Arun District Council, Civic Centre, Maltravers Rd, Littlehampton, West Sussex, BN17 5LF
www.arun.gov.uk

P/59/22/L

Pennicotts Farm Pagham Road Pagham PO20 1LN

Listed Building consent for works associated with refurbishment of property pursuant to Listed Building Consent reference P/123/20L for the demolition of existing conservatory to southern side of building & general repair & maintenance of external brickwork & roof coverings, replacement windows etc. Internal alterations comprising the removal of partition walls, reinstatement of wooden balustrade to staircase, and general repair, maintenance and refurbishment.

Title House B Staircase
D-D Section

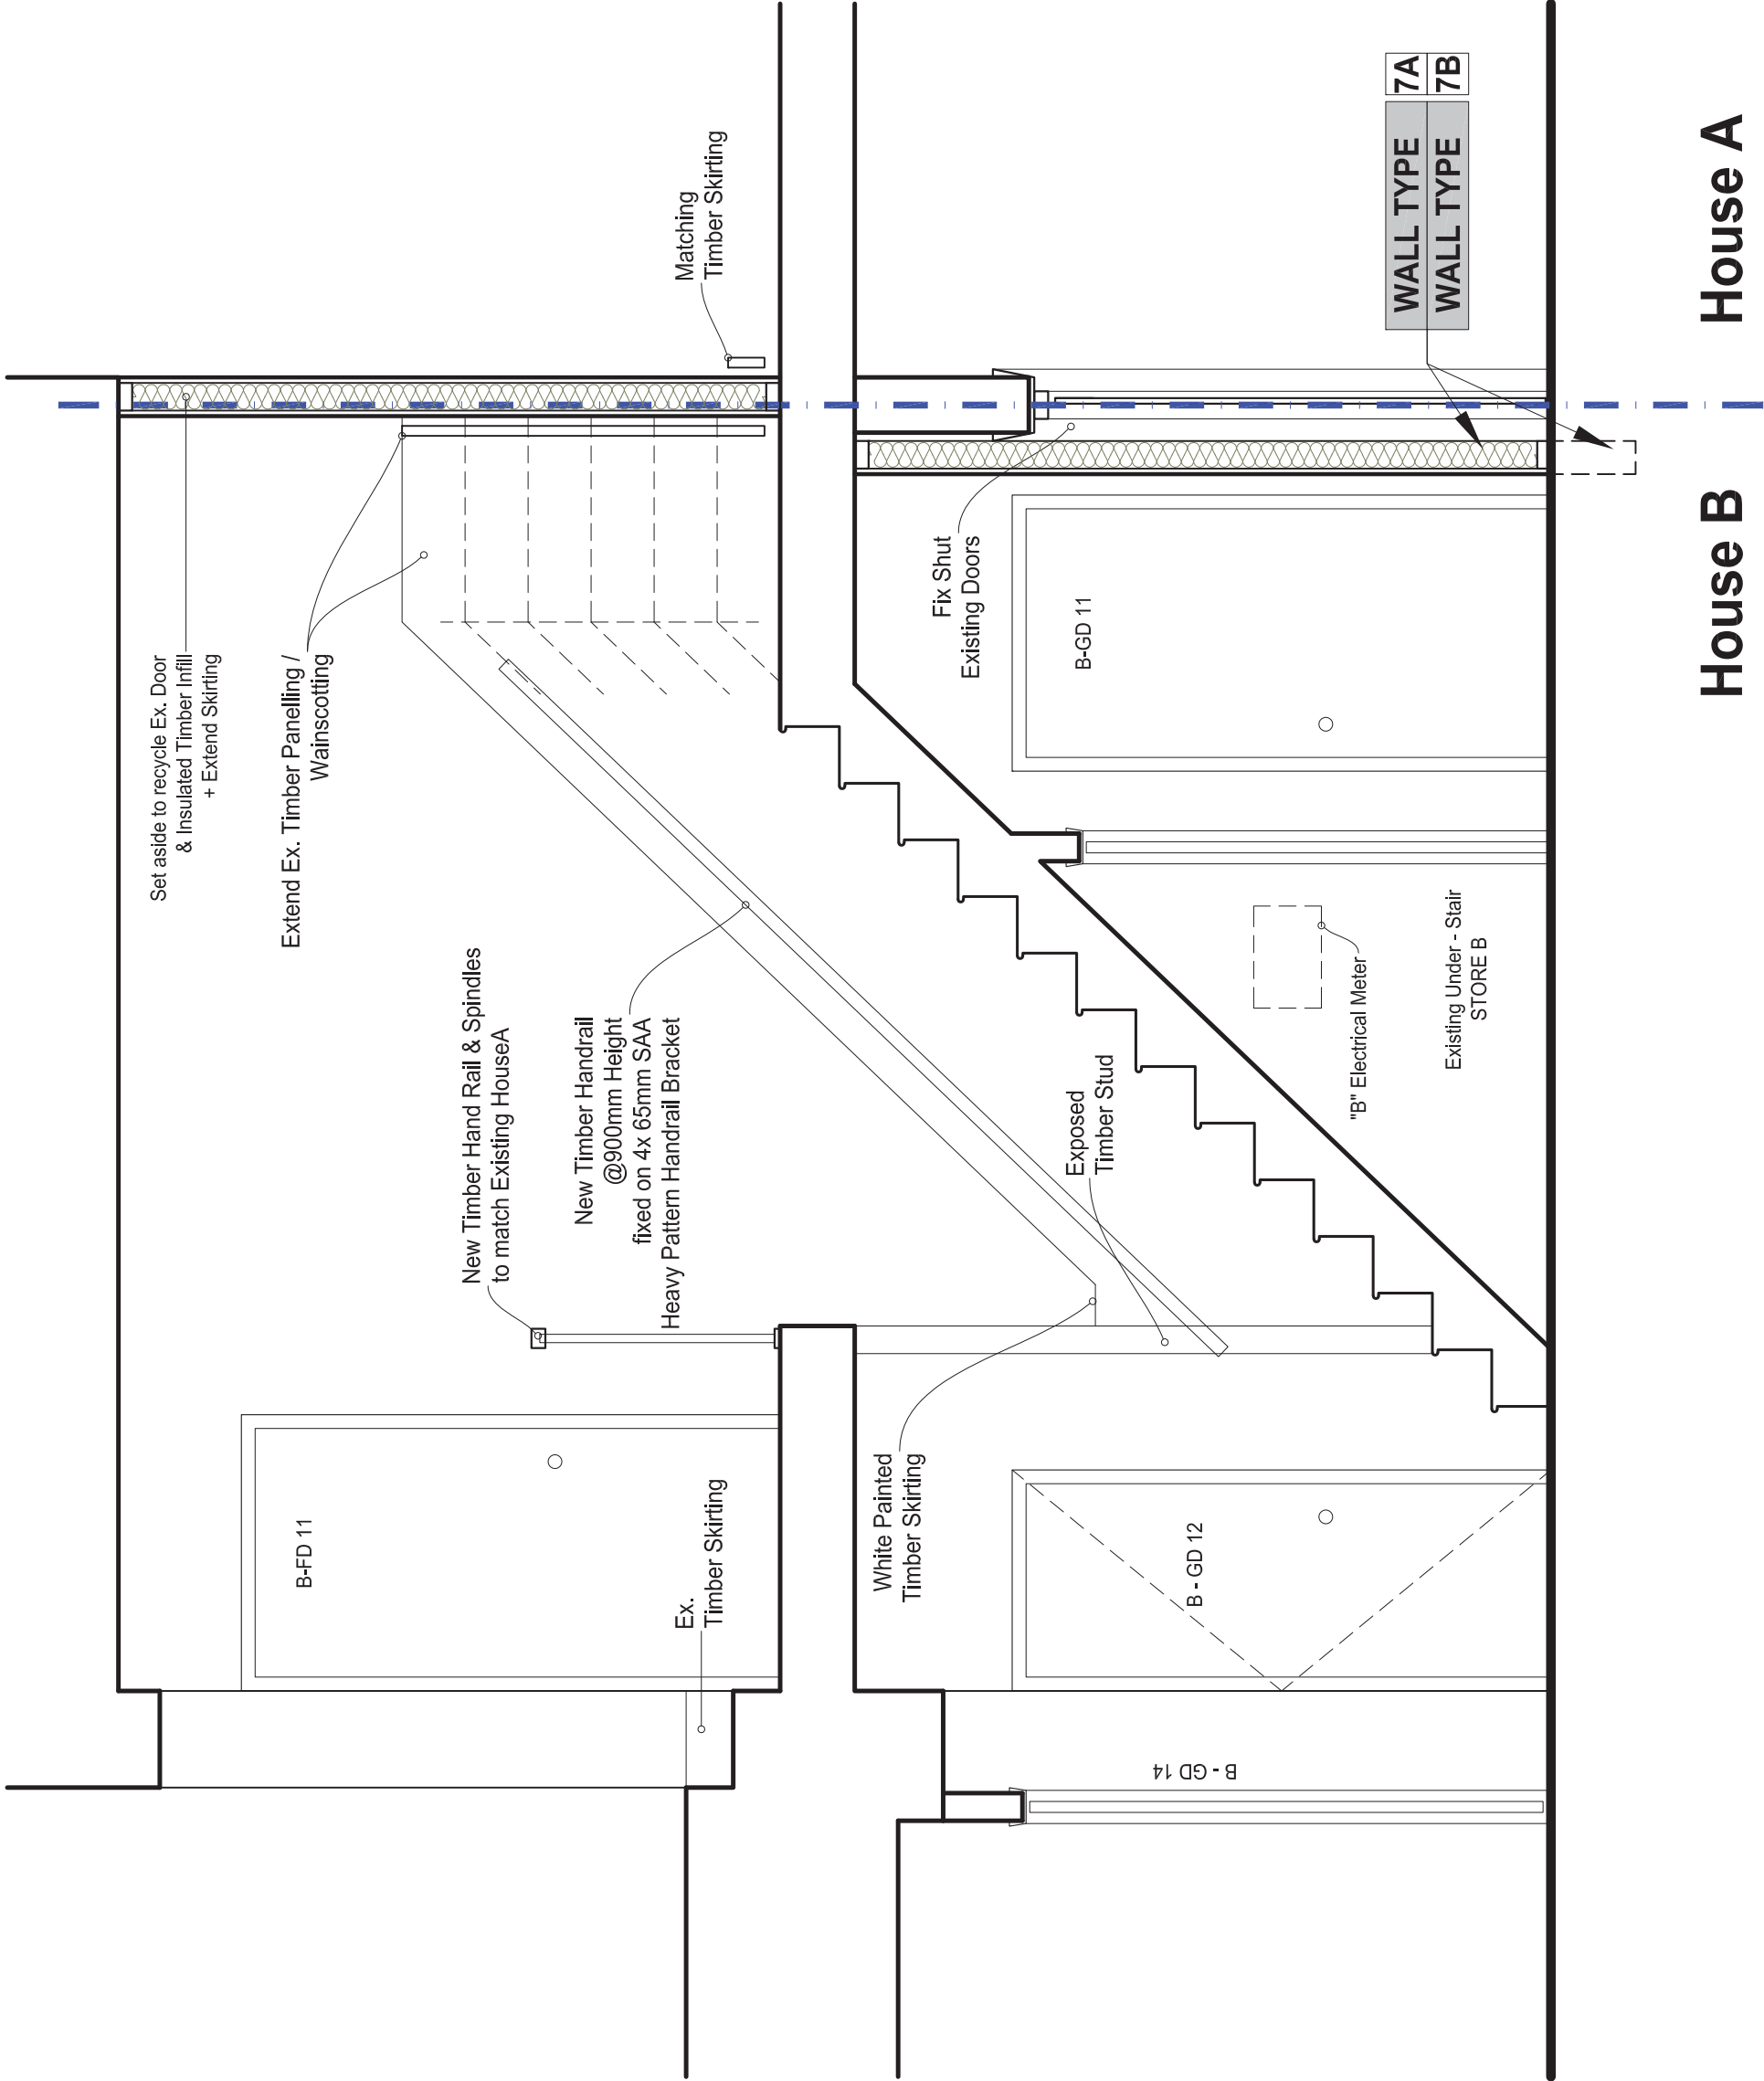
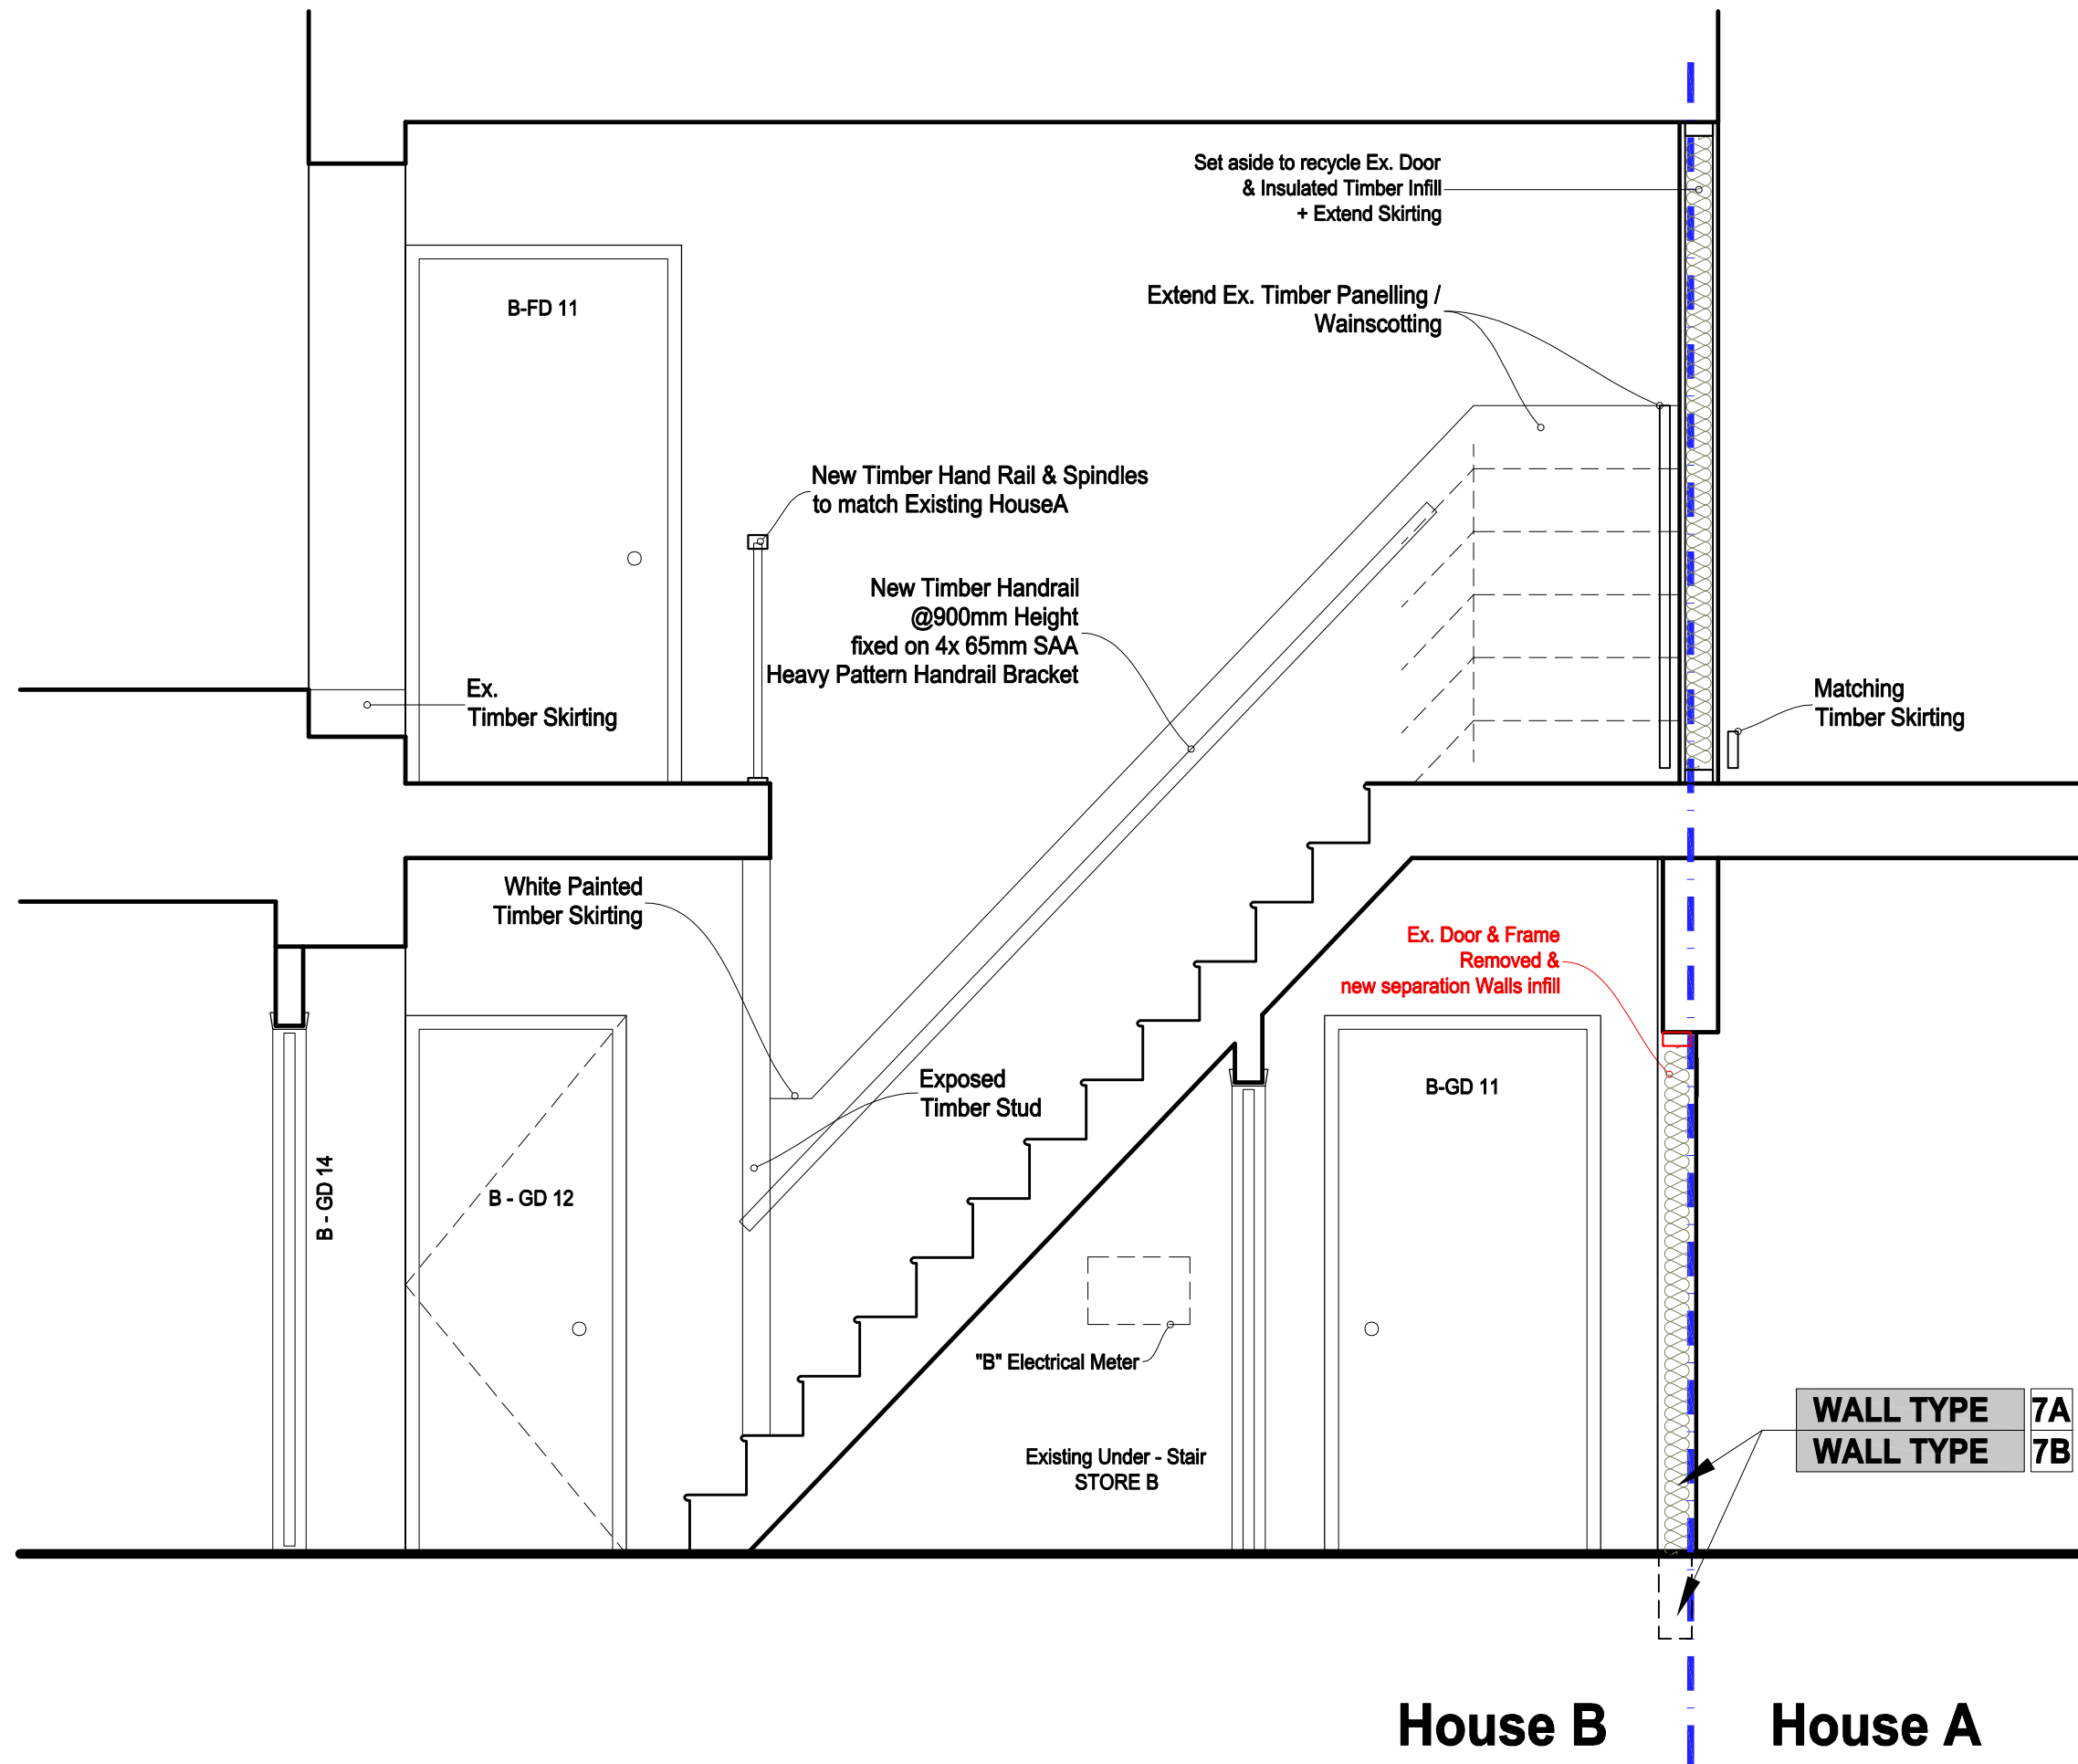
There remains some inconsistency in the plans – I note that door A-GD 13 is to be removed on the floor plans (GF Plan Structure) and replaced with ‘new infill walls’, but the plans ‘House B Staircase D-D section’ indicates that the same door is to be fixed shut. Which is correct?
